# **CITY OF PORTLAND, MAINE**

## **HISTORIC PRESERVATION BOARD**

February 19, 2015

Re: Alterations to rear ell, including windows, siding, entry, and dormer / clerestory

A-2  
 SECTIONS

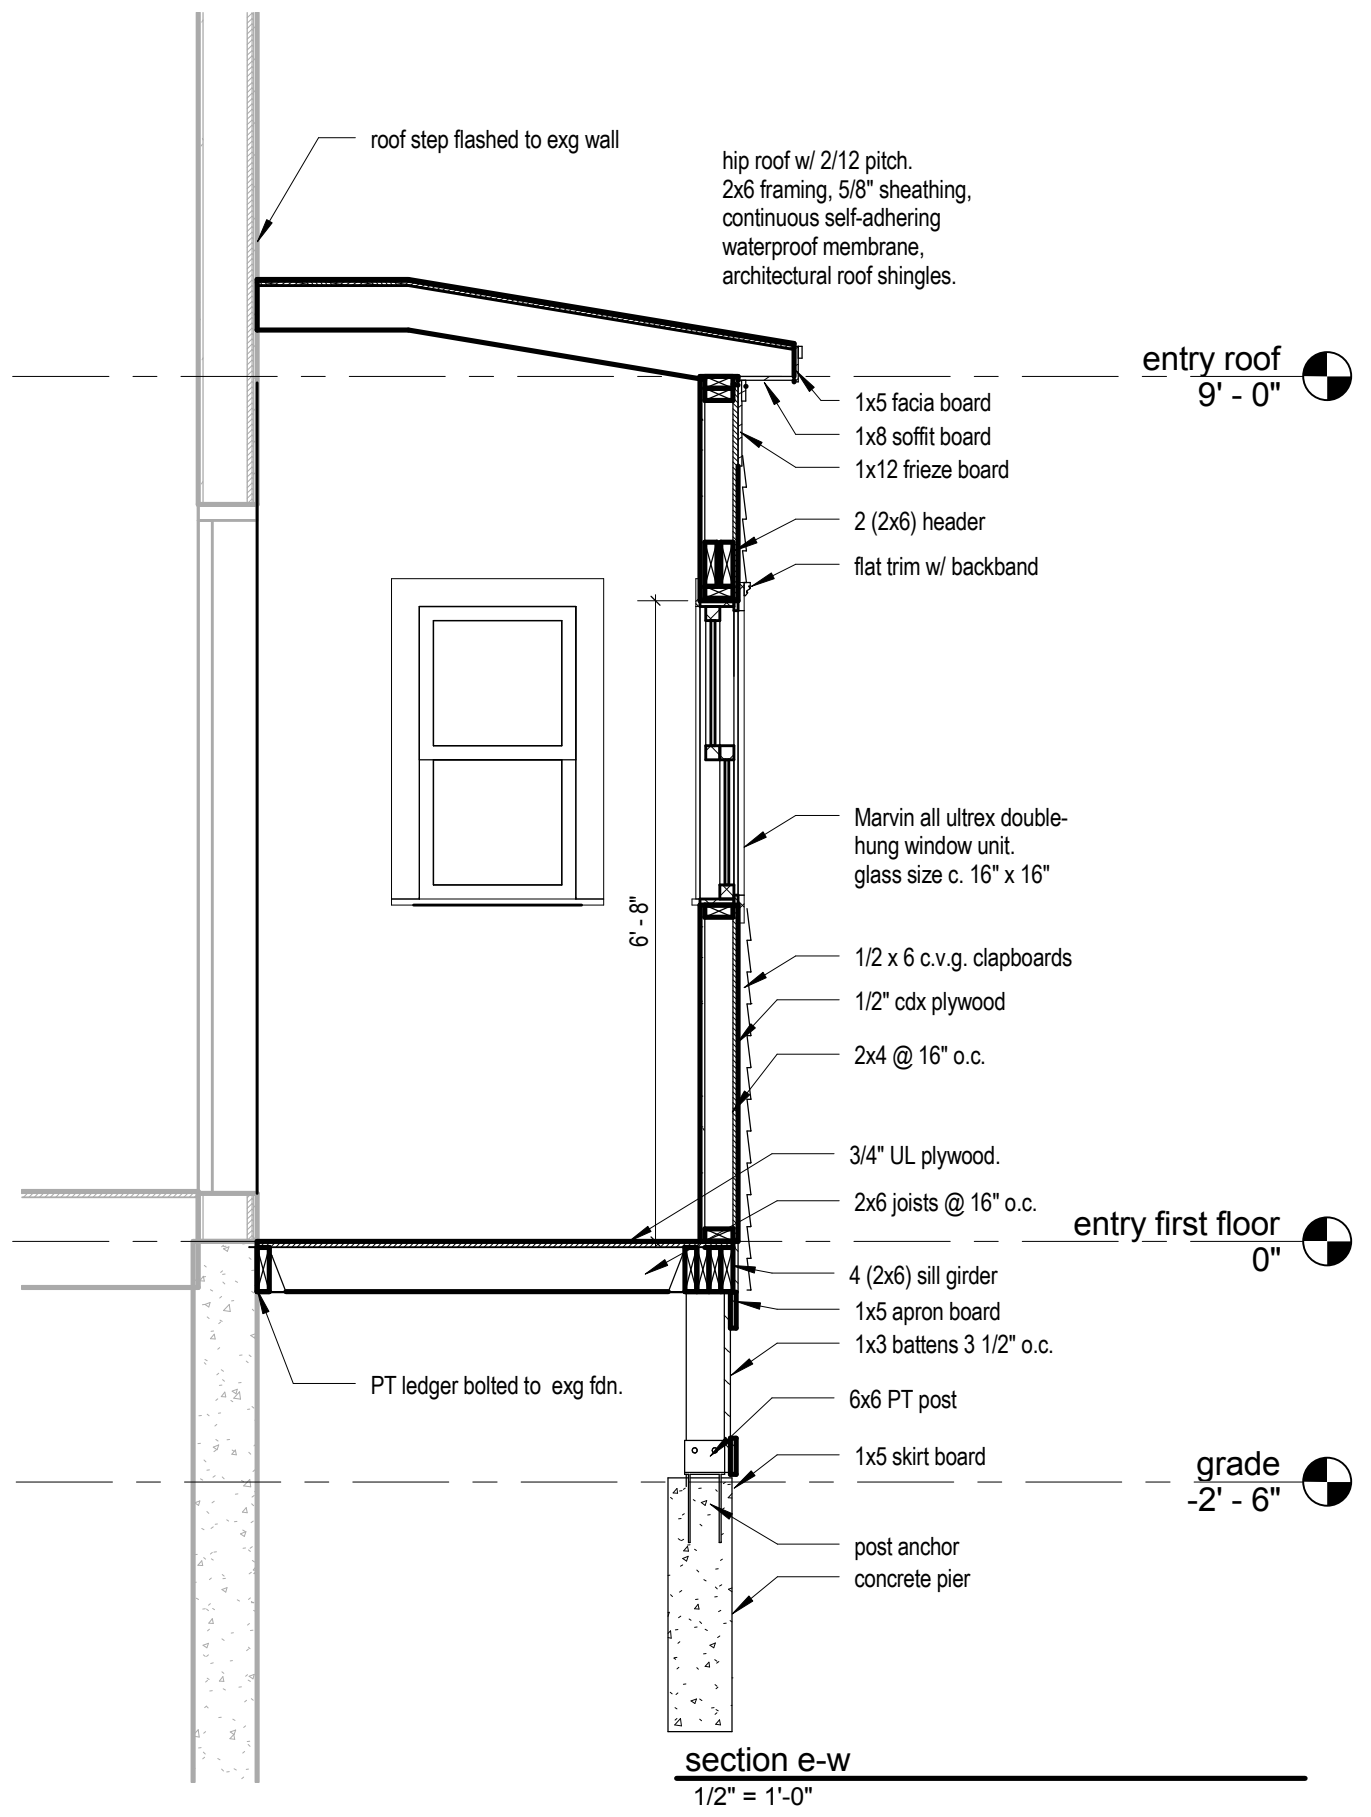
- The windows in the enclosed entry are to be sized to have proportions (of width to height) similar to the existing windows in the ell, rather than having the same width as the existing ell windows but less height.
- Glazing in all new windows is to read as clear glass, with a visual transmittance ratio (V.T.R.) of at least 70% (.7.)
- Exterior lighting is to be reviewed by staff prior to installation.
- If applicants wish to propose an alternate window configuration for the dormer / clerestory, the revised design is to be reviewed and approved by staff prior to start of construction.
